A30 Chiverton to Carland Cross TR010026

8.1 COMMENTS ON RELEVANT REPRESENTATIONS

February 2019

Drawing Title: FIGURE 7.6 - ENVIRONMENTAL MASTERPLANS SHEET 6 OF 20

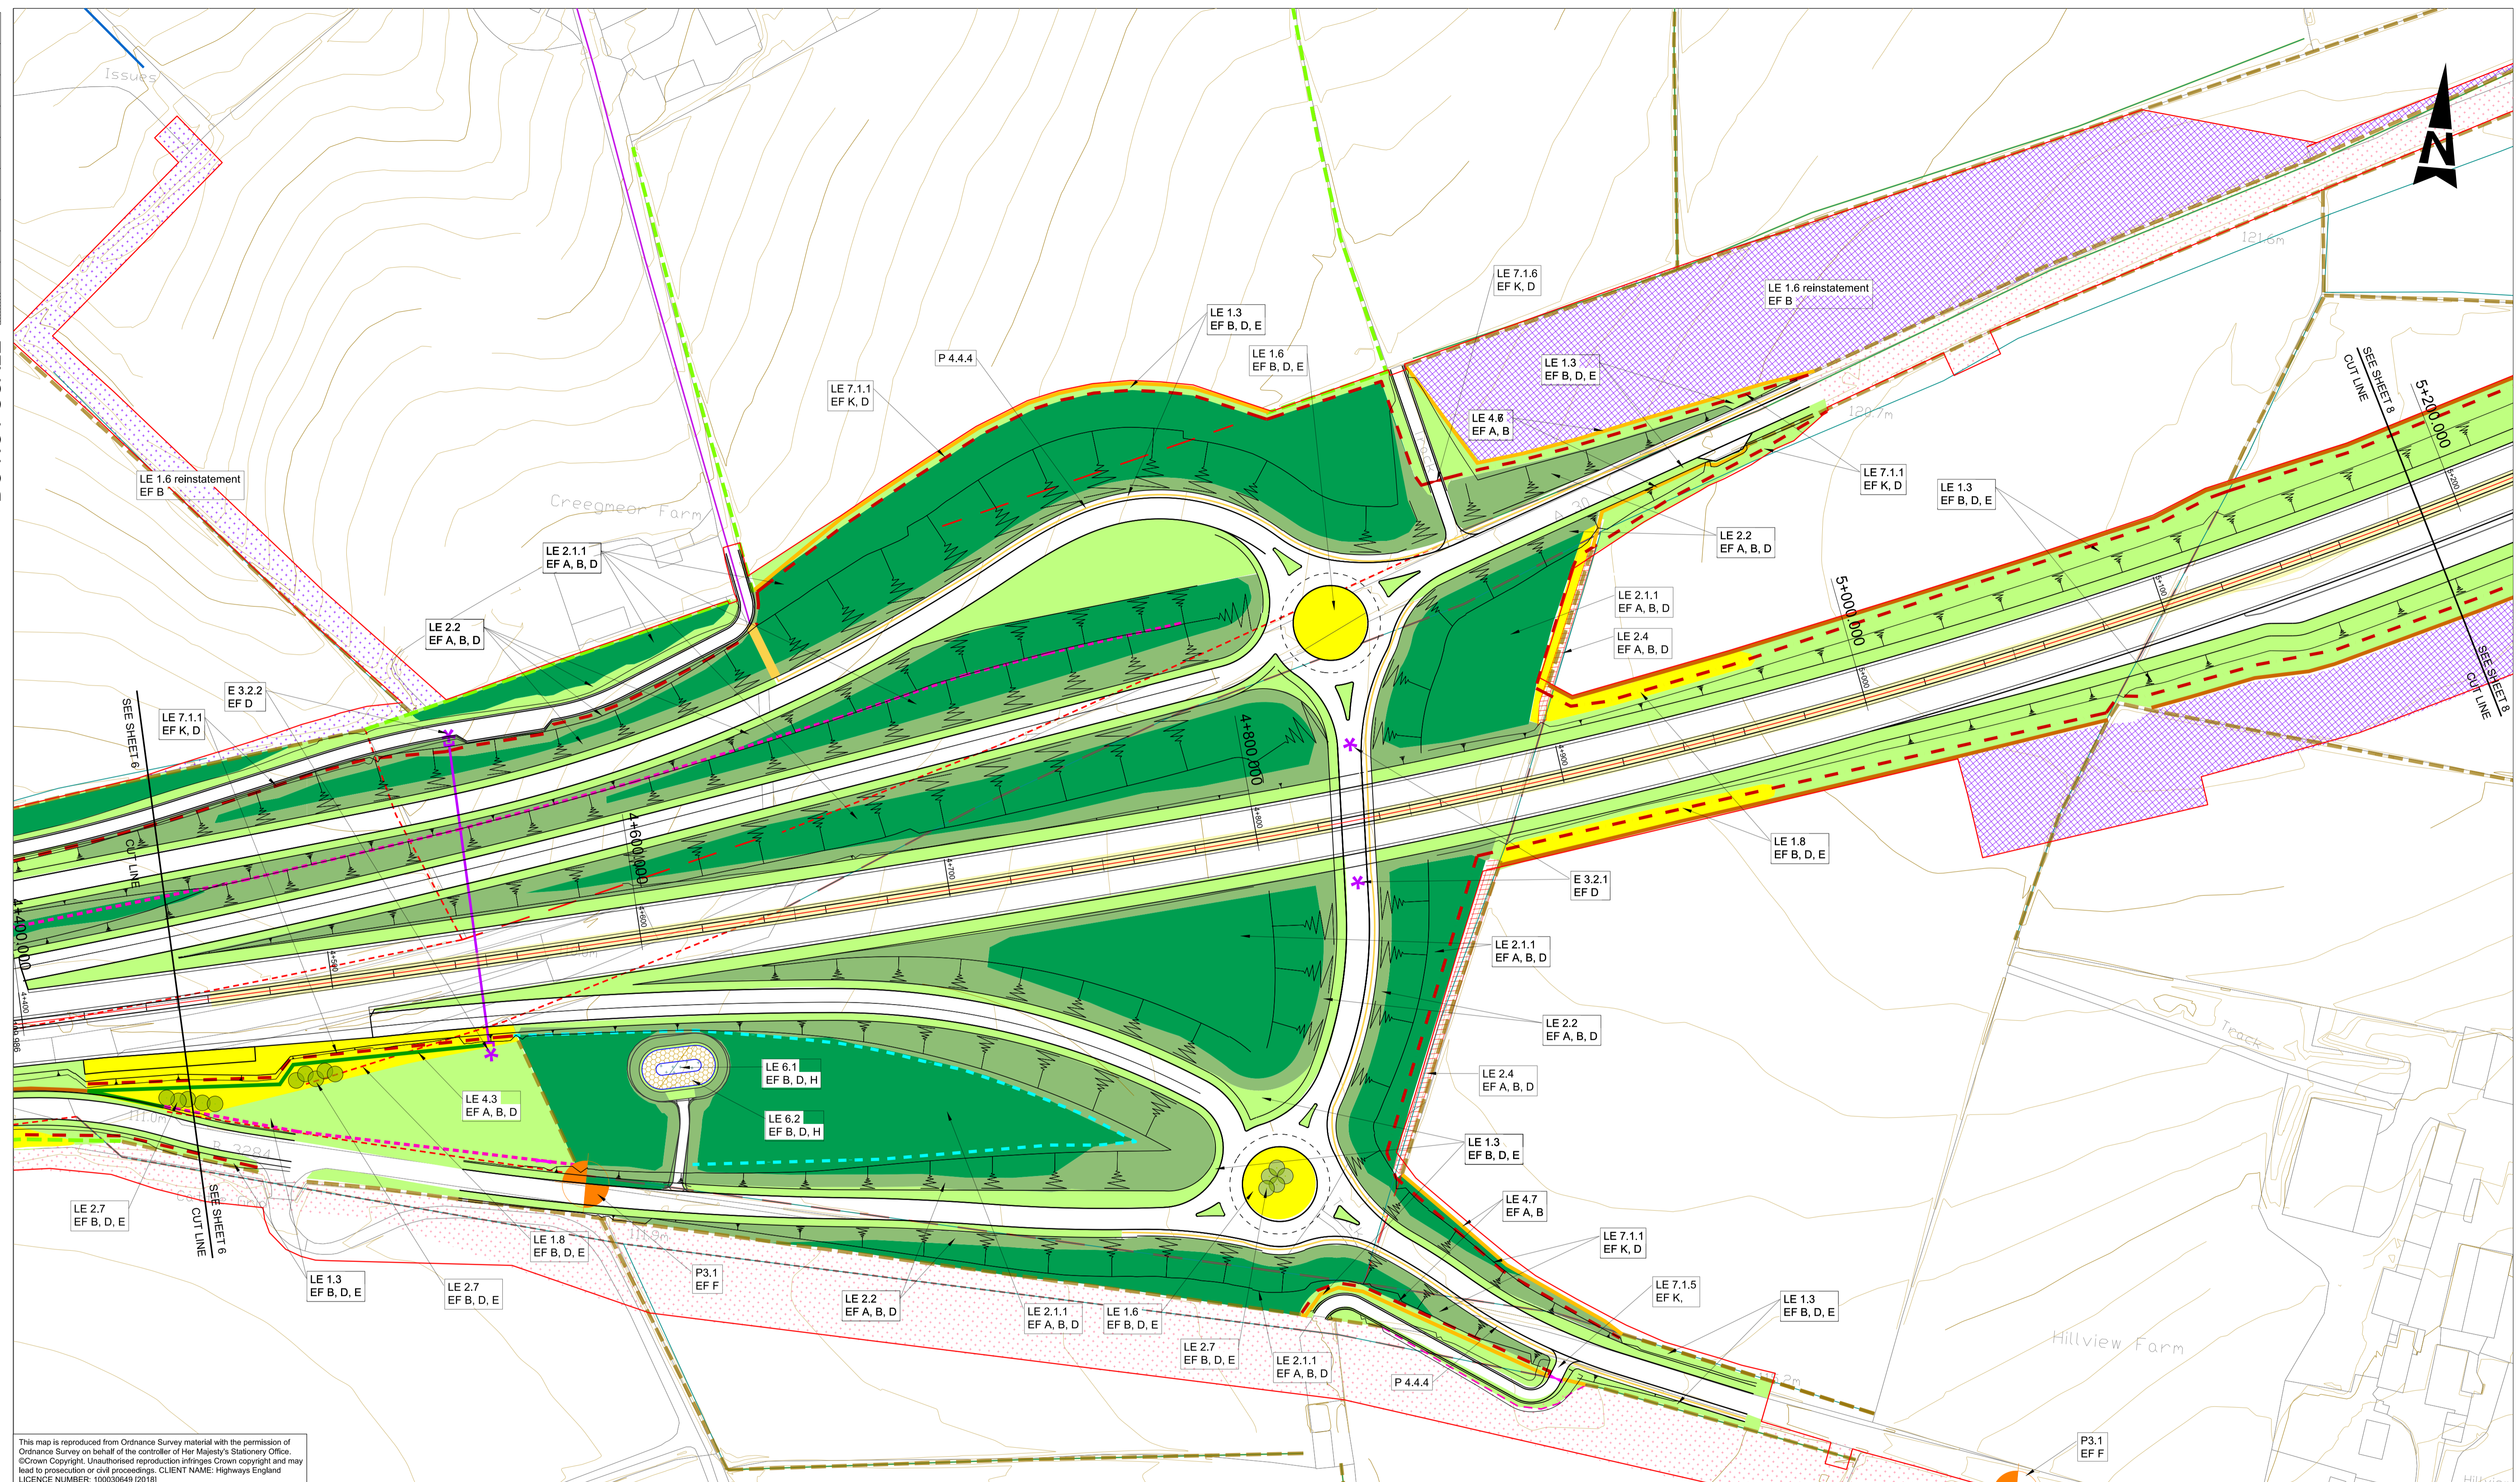
RR-109	Steve Chamberlain	Duplicate submission of RR-104, Nancarrow Farm.	All matters are covered in Highways England's detailed response to the Relevant Representation which has been sent to Nancarrow Farm, provided in Annex E of this document.
RR-035	Trewithen Estate	<p>I am representing the Trustees of Trewithen Hawkins Estate, Probus Garden Estate and STJ Galsworthy all part of "Trewithen Estate". In general we entirely support the proposed scheme</p> <p>We are concerned at the amount of land being taken on the north-west side of the underpass at Trevalso Farm, Zelah and the effect this will have on Polstain farm. We think that a better layout can be constructed without taking so much land. Drawing No HA551502-ARP-LLO-SW-DR-ZL-000568</p> <p>We are concerned at the position of the construction compound so close to Trevalso Farmhouse. We think that a better position should be further to the north east towards Boxheater junction. Same Drawing No as above.</p> <p>We are concerned at the proximity of the "attenuation pond" at Trevalso. This is too close to the roadside barn being retained by Trewithen Estate. Same drawing No as above.</p> <p>We are concerned at the amount of land taken on the north side of the A30 at Carland Cross with access to the existing wind turbines and the effect the proposed route will have on Newlyn Downs SSSI and the Higher Tier Countryside Stewardship scheme recently agreed with Natural England. We do not consider that the "attenuation ponds" are necessary as these are taking far too much land - they should be designed much more sympathetically with the landscape. It is essential that the existing wind turbines are able to be accessed from the proposed A30 and sufficient turning areas are provided for vehicles carrying replacement blades for the turbines. Drawing No HA551502-ARP-LLO-SW-DR-ZL-000559.</p>	<p>Highways England acknowledges that the Trewithen Estate, in general, supports the scheme.</p> <p>Point 1 - Land take</p> <p>The new road layout proposed for Trevalso Lane and Herver Lane is required to maintain the connection of Trevalso Lane to the existing A30 and has sought to minimise land take as much as possible.</p> <p>The realigned Trevalso Lane would cross the new and existing A30 through an underpass and connect to Herver Lane, which would also be realigned to maintain its junction with the existing A30.</p> <p>This is the preferred layout for this junction as it maintains Herver Lane as a through-route to its connection to the existing A30, whilst facilitating its new junction with the realigned Trevalso Lane, as discussed and agreed with the adjacent properties on Herver Lane (see Appendix B of the Statement of Reasons (Document Reference 4.1) [APP-006].</p> <p>The designed realignment provides the required separation between the Trevalso Lane underpass and the junction to allow acceptable vertical gradients and a required level area on the approach to the junction. This is Work Number 10 in the draft DCO (Document Reference 3.1(B)) [AS-031] and is shown on Sheet 6 of the Works Plans (Document Reference 2.4(A)) [AS-019].</p> <p>Point 2 - Construction compound</p> <p>The construction compound at Trevalso Lane is a satellite compound for the construction of the Trevalso Lane underpass structure. The compound has to be in close proximity to the structure because it serves the construction site in terms of labour, plant and materials. In response to matters raised at statutory consultation, the compound has been reduced from its original size and the new size and location was agreed with the tenants on the farm (see page 135 of the Consultation Report, Document Reference 5.1) [APP-029].</p> <p>Point 3 - Attenuation pond, Trevalso</p>

Reference	Interested Party	Relevant Representation	Highways England Response
			<p>The attenuation pond at Trevalso is located close to the low point in Trevalso Lane and so there is limited opportunity to move the location as shown in the design (see Sheet 6 of the General Arrangement and Section Plans (Document Reference 2.6) [APP-017]. During the detailed design stage, this pond could be lined and would have no impact on the adjacent existing roadside barn. However, the distance between the pond and the barn would be maximised as far as possible during detailed design.</p> <p>Point 4 - Carland Cross</p> <p>The proposed land take at the Carland Cross windfarm is required to provide the realigned main access to the windfarm and the associated accesses to turbines 2 and 3 within the windfarm to the requested Scottish Power Renewables (SPR) standards. This layout has now been agreed with SPR (see Annex D of this report). The two attenuation ponds are required to hold the new road surface water run-off before discharging to the existing watercourses to the north-west and north-east of the junction at the equivalent rate as the run-off from the existing fields. This is a requirement of the Environment Agency and Cornwall Council and therefore there is no scope to reduce their size.</p>
